14725 Trigger Road, AL-23-20

Please accept the following comments from El Paso County Public Health (EPCPH) for the project referenced above:

APPROXIMATE
DIMENSIONS FOR
LOCATION OF SUBJECT

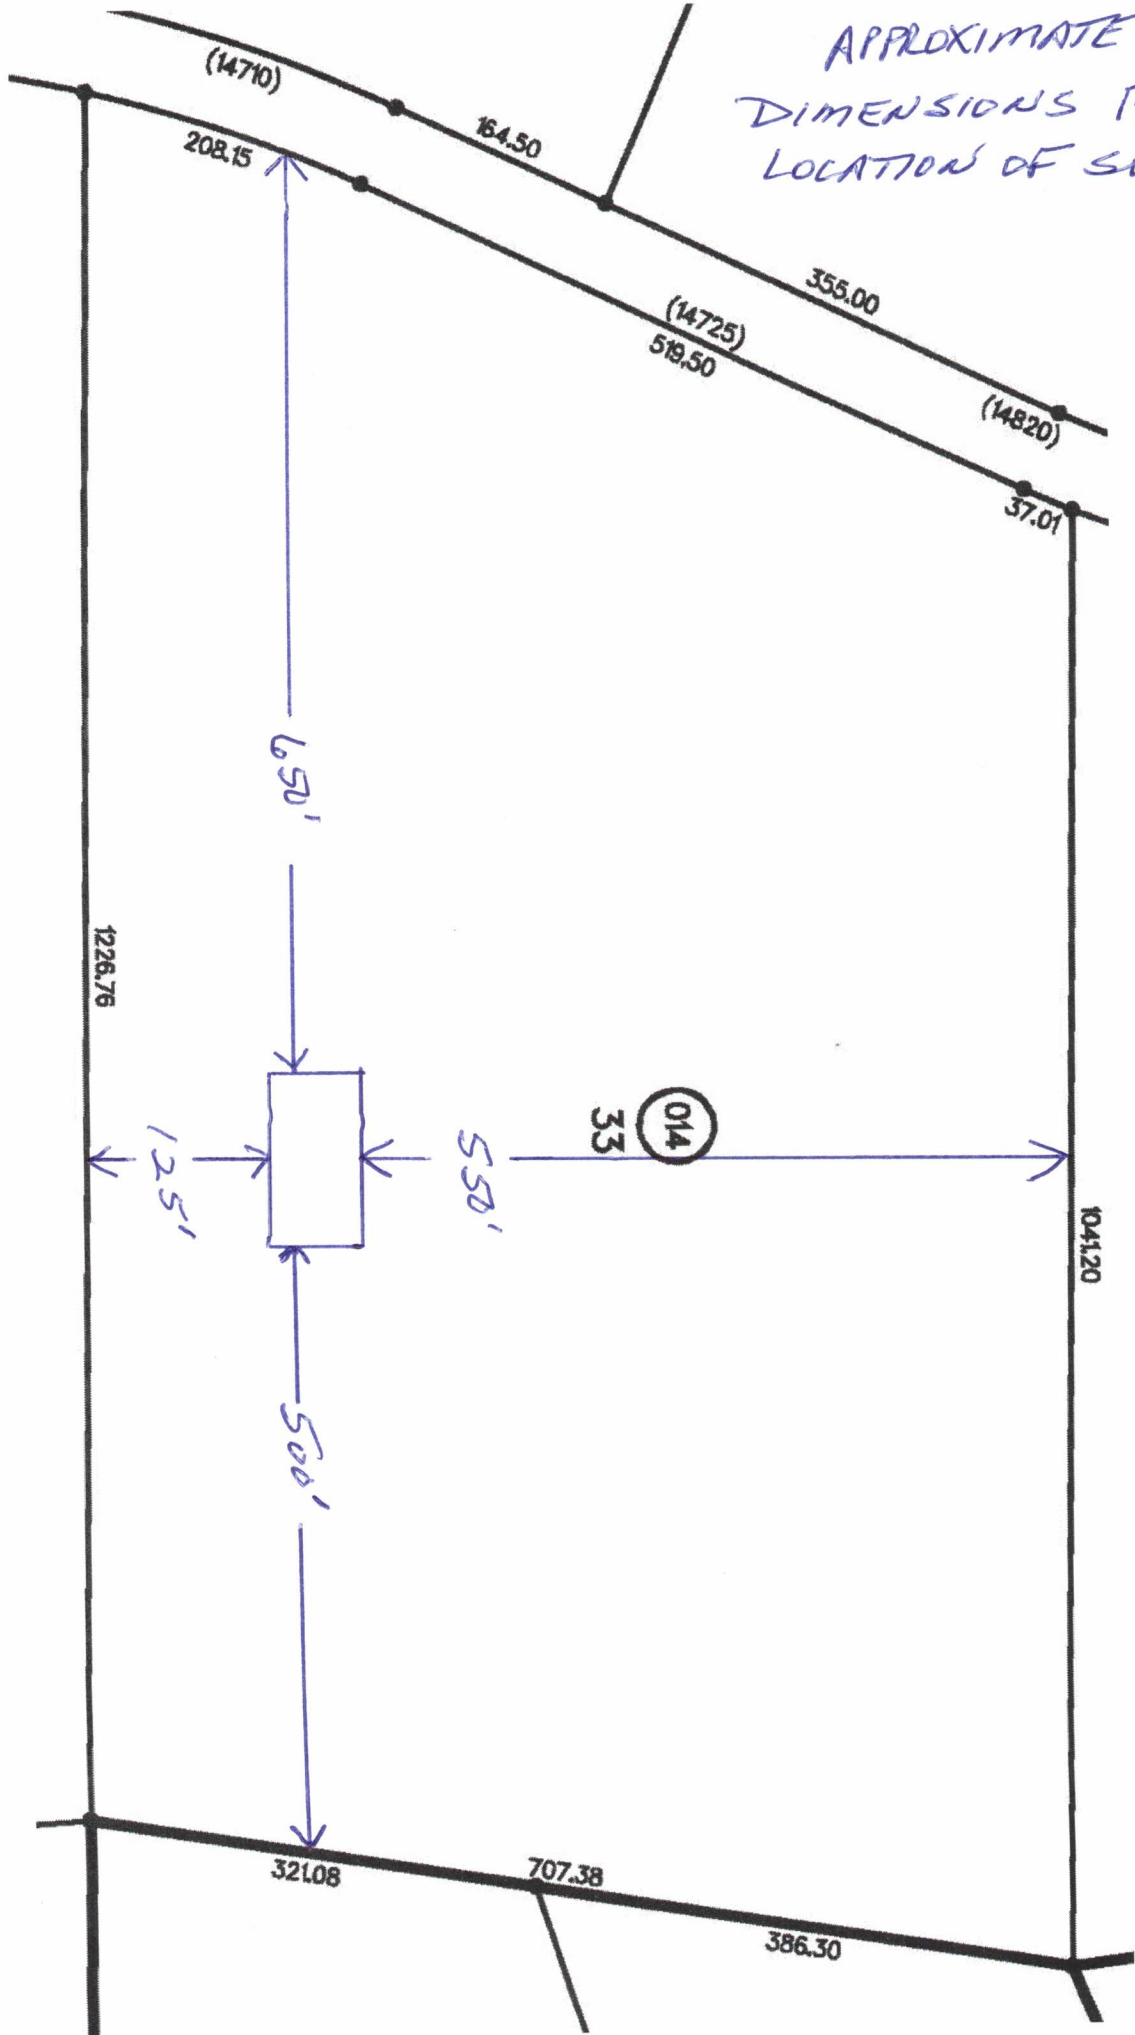
- **Water service for the existing house is by an individual private well.**
- **Wastewater service for the existing house is an onsite wastewater treatment system (OWTS) permitted, installed, and approved in 2019 for a 4-bedroom house.**
- **The planned second house will require full compliance with the El Paso County Public Health Onsite Wastewater Treatment System Regulations.**
